HTE# BRES-2005-00<sup>41</sup>

EXISTING SEPTIC SYSTEM INSPECTION

ADDRESS OF OWNER (IF DIFFERENT) Physical 1118 OAK GROVE CHURCH RD Anglen N.C. 27501 lot 4

SITE PLAN

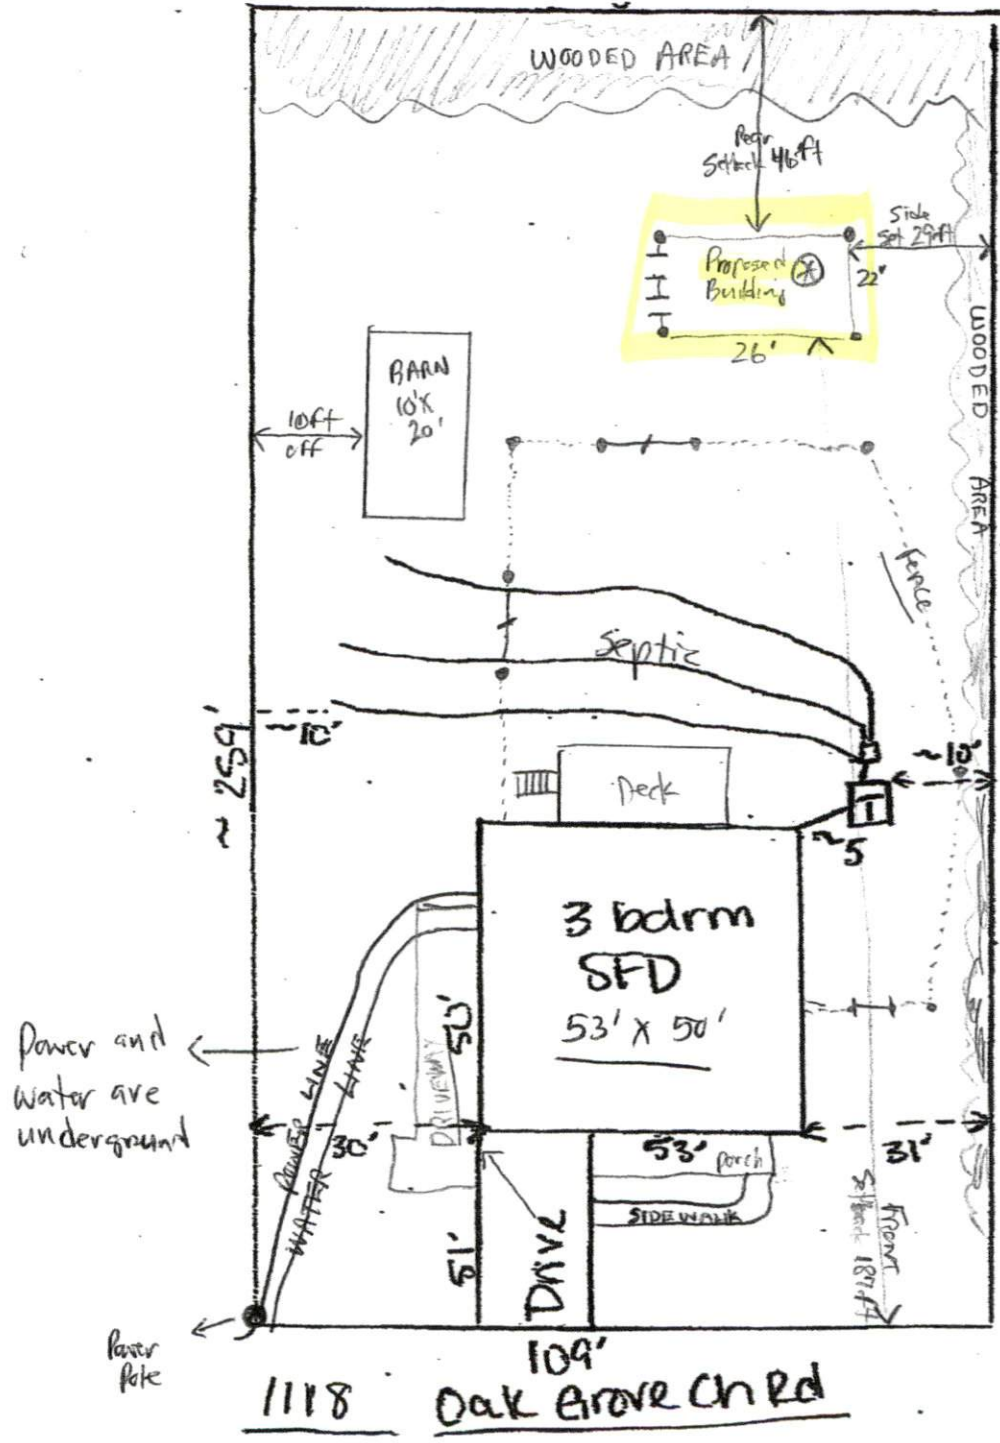
22x26' STORAGE BUILDING

**BUILDING MUST BE 5' FROM ANY PART OF SEPTIC SYSTEM  
DO NOT DRIVE OR PARK ON SEPTIC SYSTEM**
